KITTITAS COUNTY

DEPARTMENT OF PUBLIC WORKS

RE: Suncadia Phase 2 Division 5
River Ridge II

I have completed review of submitted engineering materials supporting Suncadia Phase 2 Division 5 (River Ridge II) plat. My review comments appear below for your use.

Hazardous Slopes

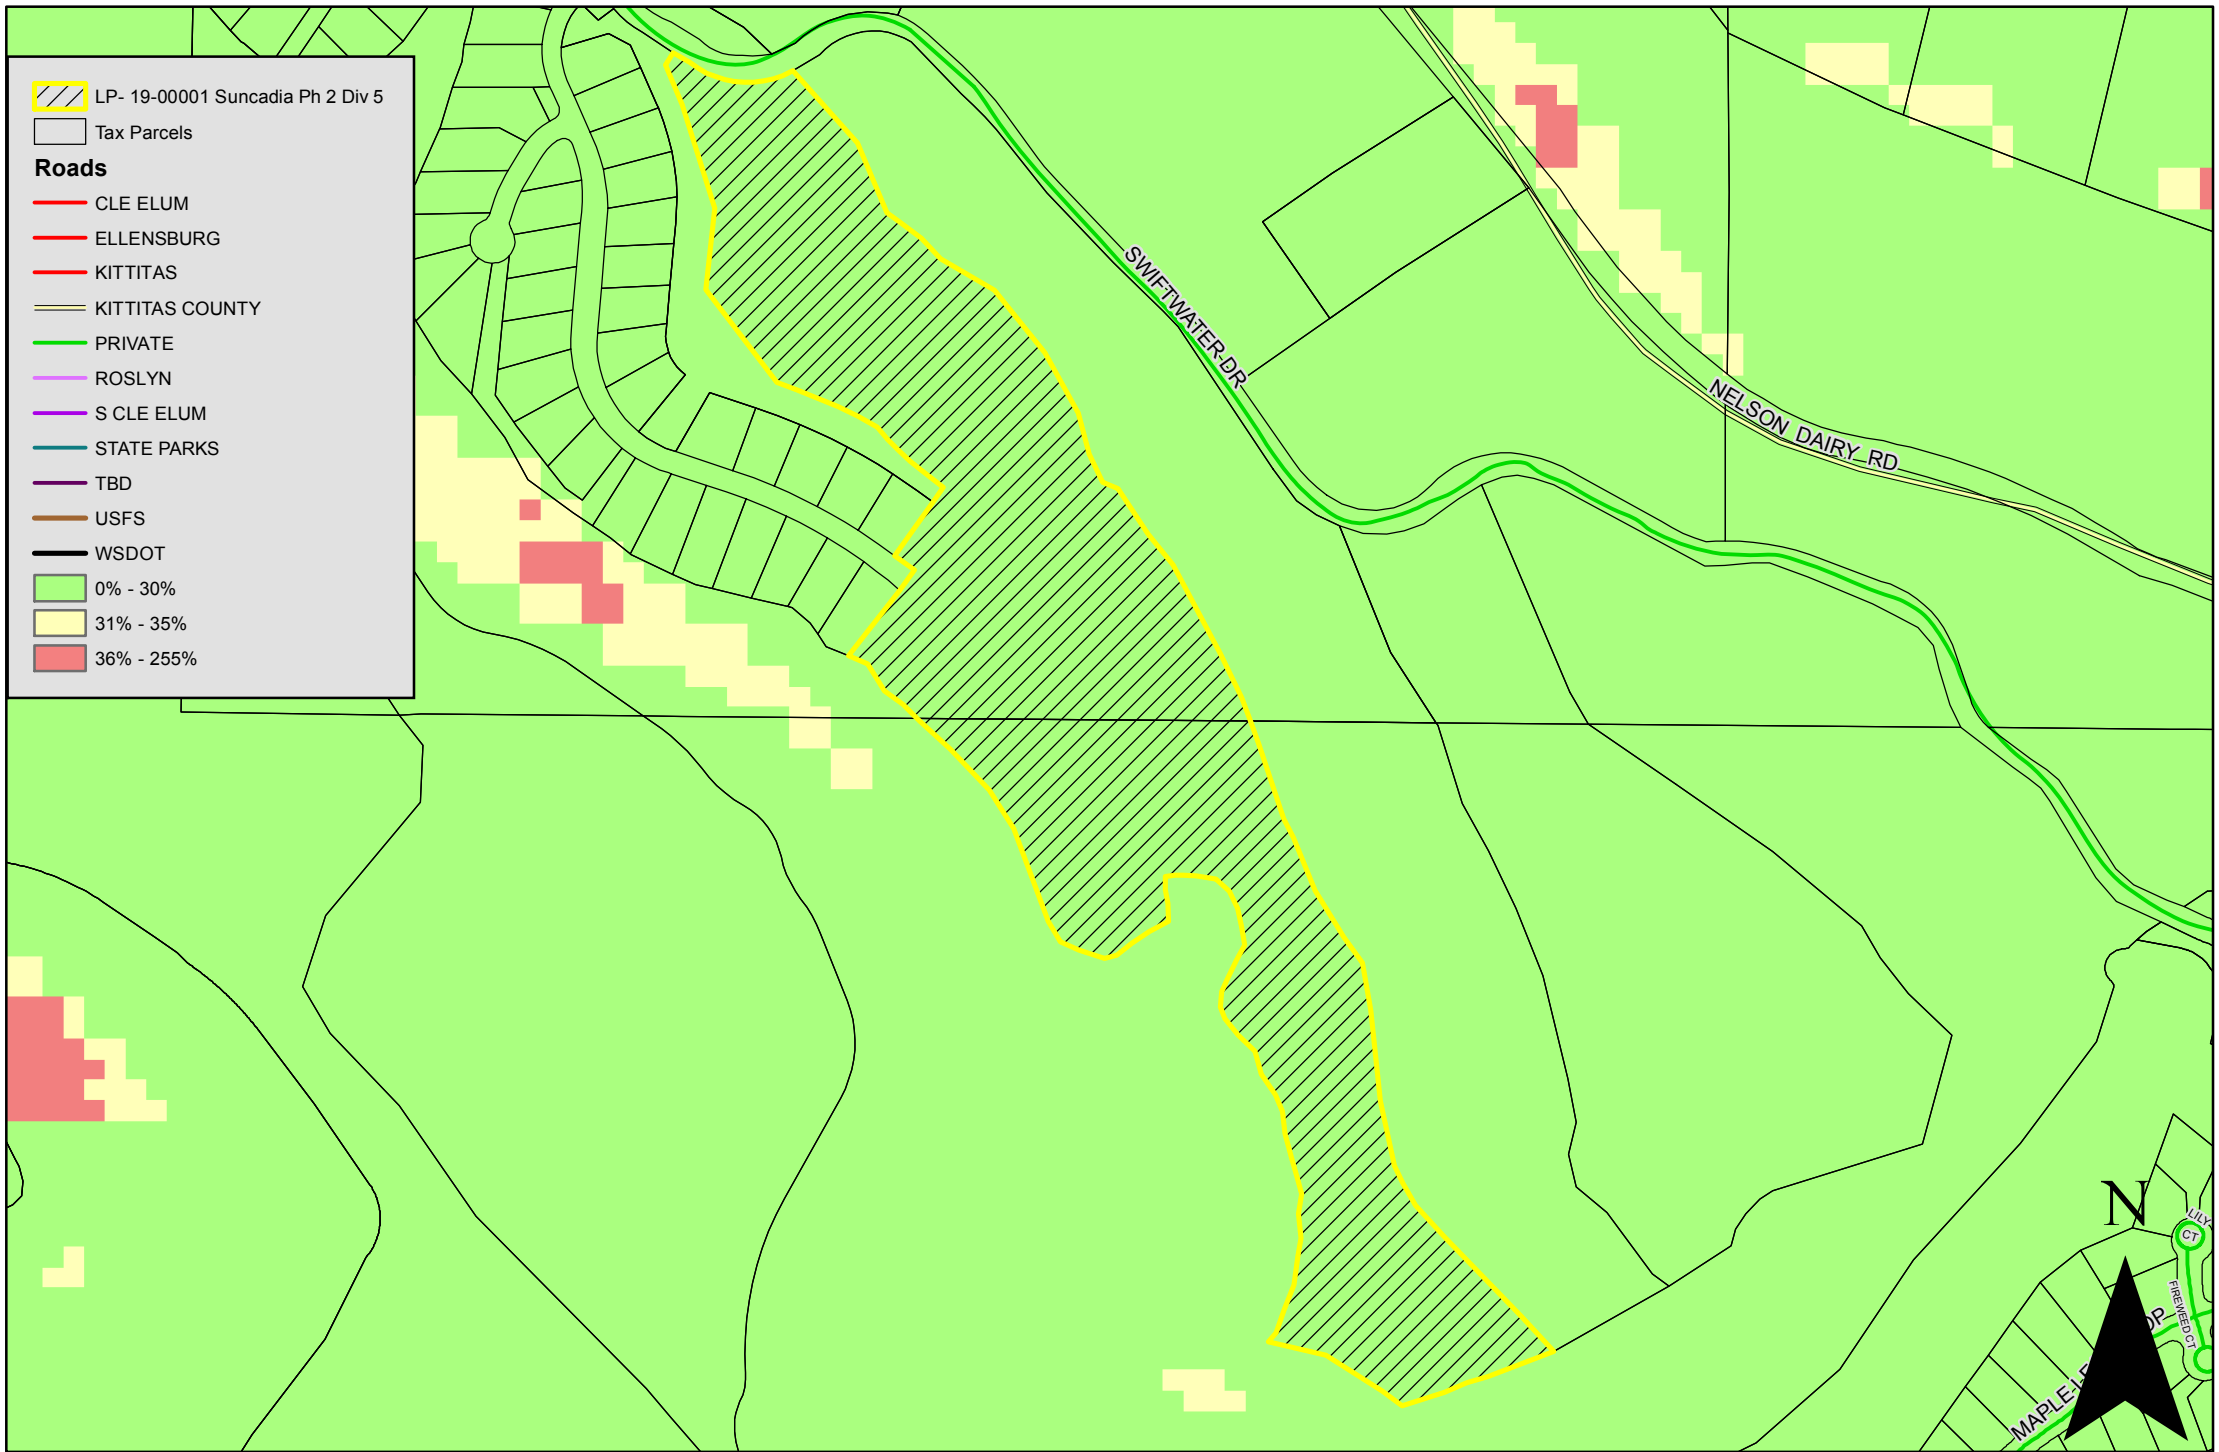
2. Conceptual Utility Plan
 - A. The supplied plan does not provide sufficient detail for substantive utility review.
 - B. The biofiltration swale depicted on lot S-4 appears to be situated immediately up-gradient of a steep slope area. Please affirm that no slope instability is anticipated as a result of the biofiltration swale's proximity to the the top of slope. Similarly, the dispersion path appears to site closely to the top of slope. The proposed dispersion area on lot OS-4 is also close to the top of slope. Please affirm that no bank instability is likely to result from the location of the dispersion areas.
